Application for a non-material amendment following a grant of planning permission.
Town and Country Planning Act 1990

ERECTION OF EXTENSIONS AND DORMER WINDOWS TO SIDES

Application Number: 2017/62/93806/E

Add a small roof light on the flat roof area between the two dormer extensions. Client wanting to use a 600x900 roof light.

Proposed Side 1 Elevation

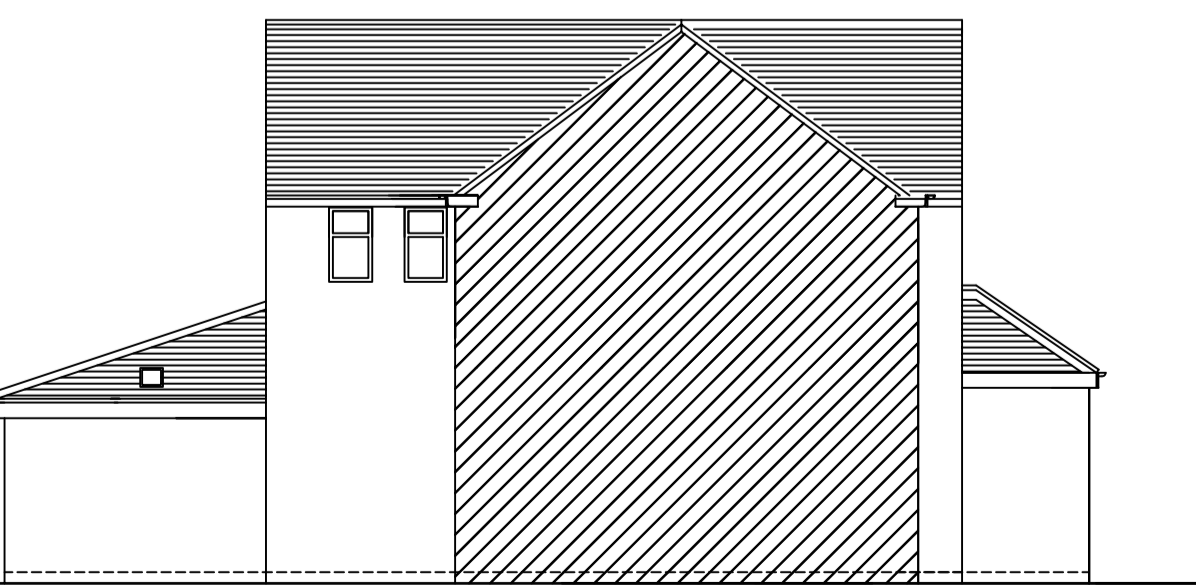
Clients wish to bring natural daylight into the central circulation space up to the new dormer floor level to avoid having to use electric lights during daylight hours.
